Your Ref: OWPC18116
Our Ref: FG/42/18/HH 07-03-2018
Please ask for:
Ross Leal

Demolition of existing detached garage & rear conservatory, enlargement of existing driveway, single storey side extensions, extension of existing roof over proposed extensions with 5 No. dormer windows.

17 Foamcourt Way Ferring

Thank you for your internet representation made on 7th May 2018 which has been recorded as **'an objection'** with the comments as follows:

Title
**EXISTING AND PROPOSED
ELEVATIONS FROM FOAMCOURT WAY**

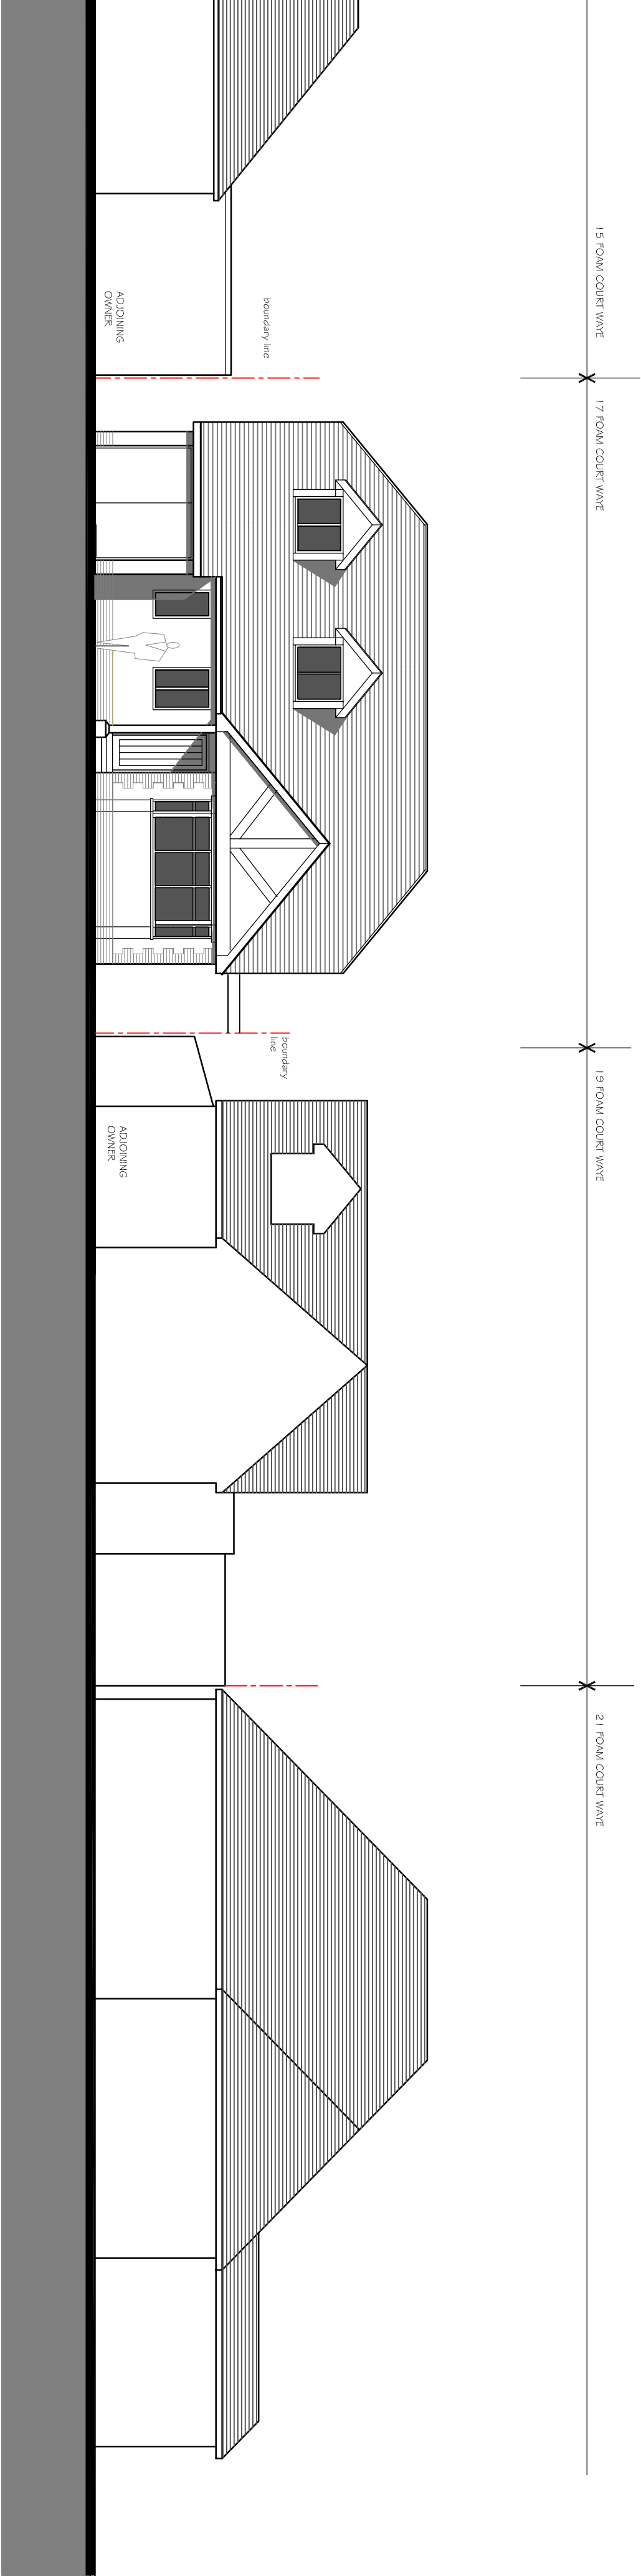
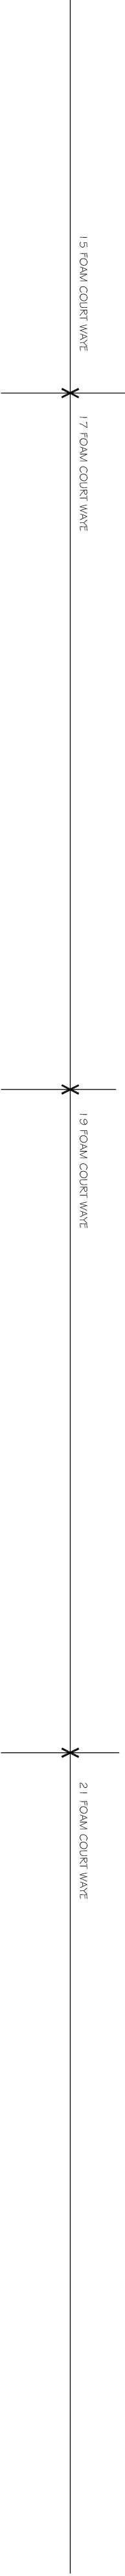
1 Increasing the roof level significantly above that of the majority of existing properties in the vicinity will change the appearance of the area, and set a precedent for future house conversions. This could lead to a 'terrace' of houses with minimal gaps between.

2 The increased roof level and build will significantly dominate the street scene and will stand out of place.

4 The proposed front and rear face areas appear to be over double that of the existing face area. This will have a significantly dominating impact on the appearance of the area.

5 The proposed ridge of the new property is FOUR TIMES the length of the existing ridge and nearly 33% higher than existing roof.

PROPOSED ROOF PLAN

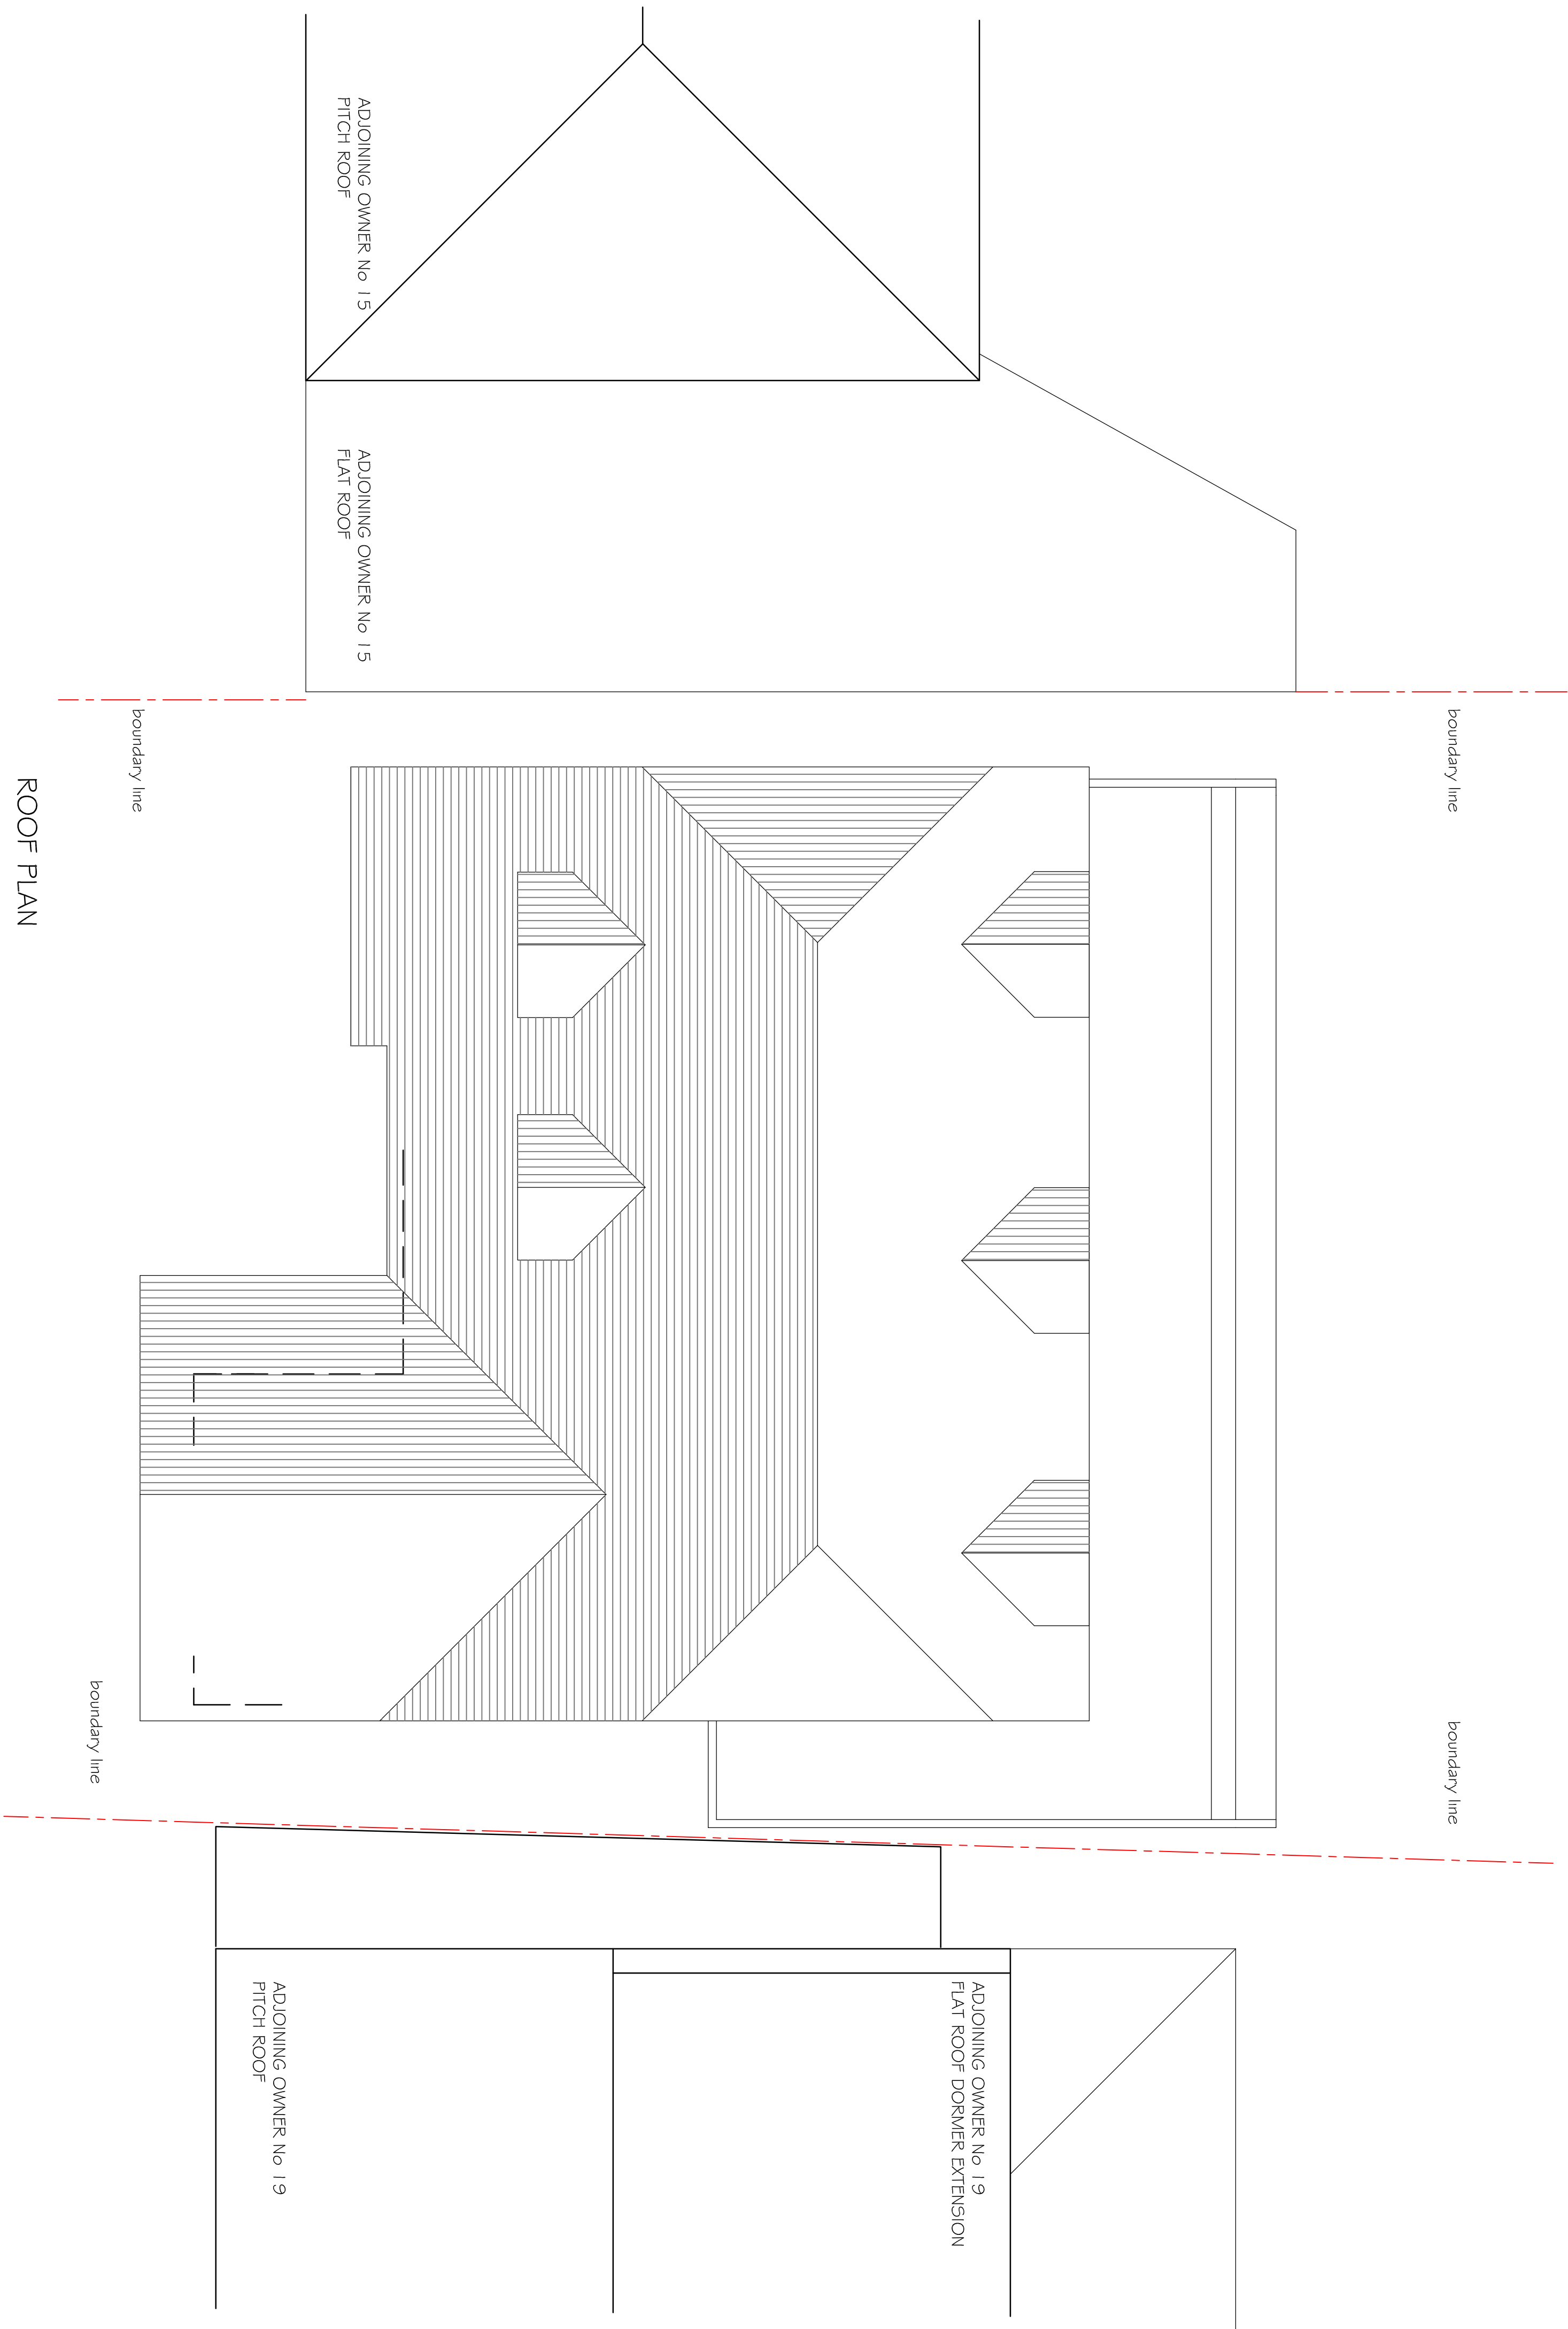
The main issue is the enormous change in size of the roof. Should a precedent be set here then it could lead to the road scene finishing up as a 'wall' of houses leading to questions on infrastructure issues, drainage, traffic movements etc.

Title		PROPOSED FRONT AND REAR ELEVATIONS	
Scale	1:50 at A1	Dwg. No.	**C.C.P.P.** A B
Date	NOV 2017		
Drawn By	SP		
CAD_ref

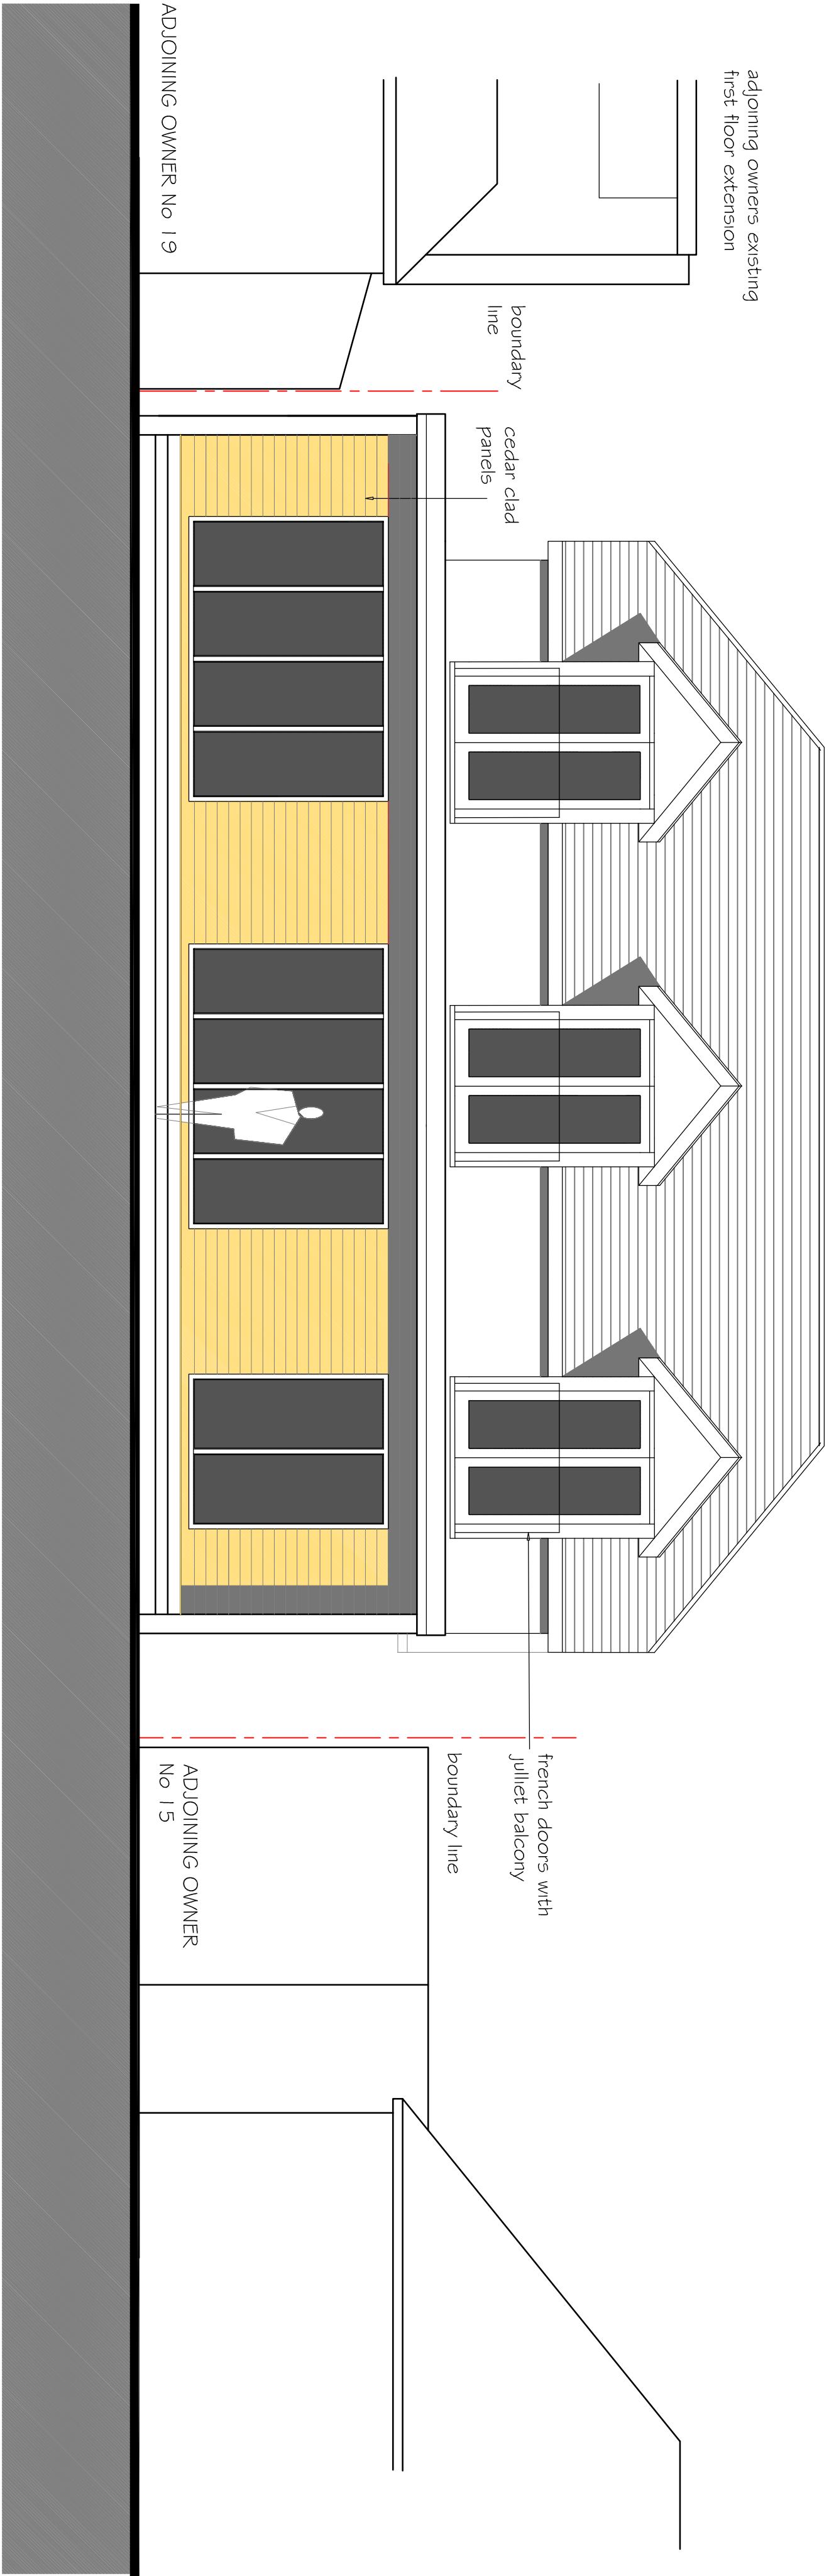
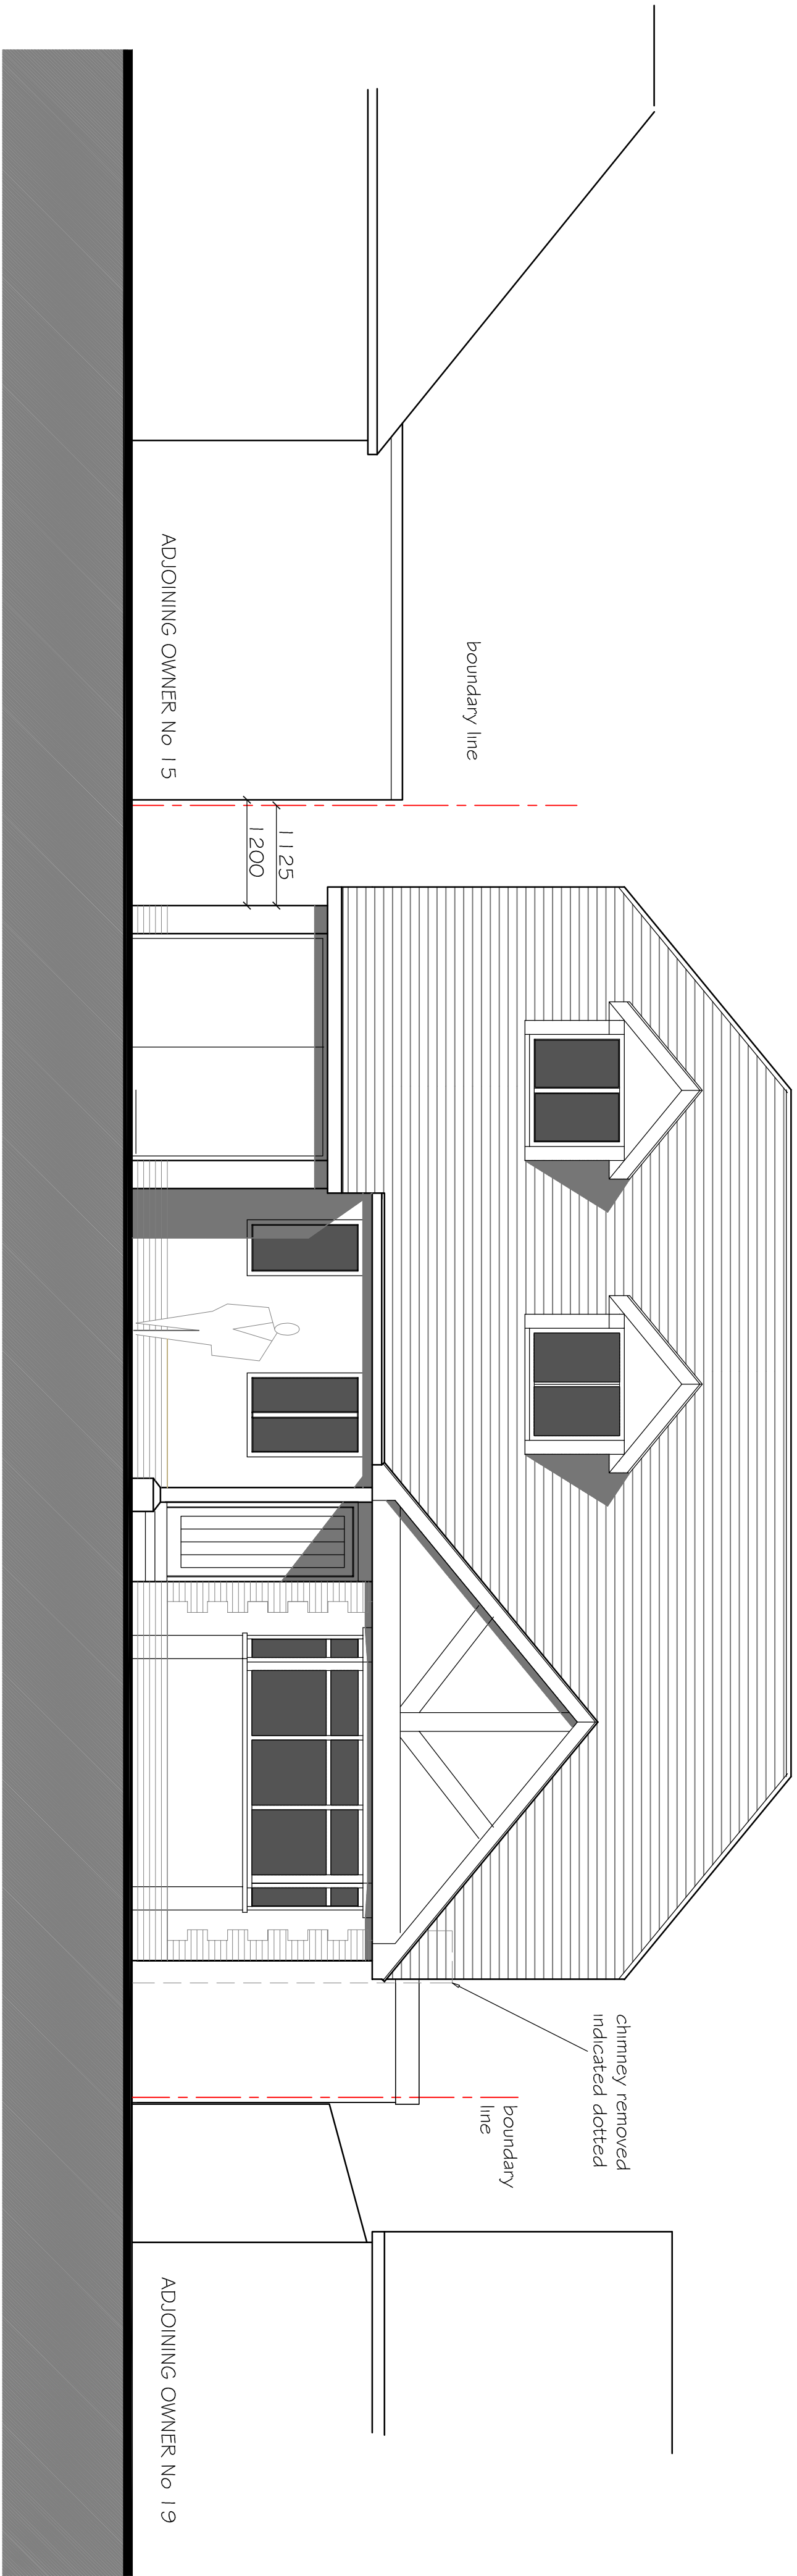
2 The two new windows facing the roadside overlooking other properties will reduce privacy of existing properties

3 The left dormer window appears to be a bathroom, even with defused glass it is inappropriate to have a first floor bathroom facing the road and peoples lounges.
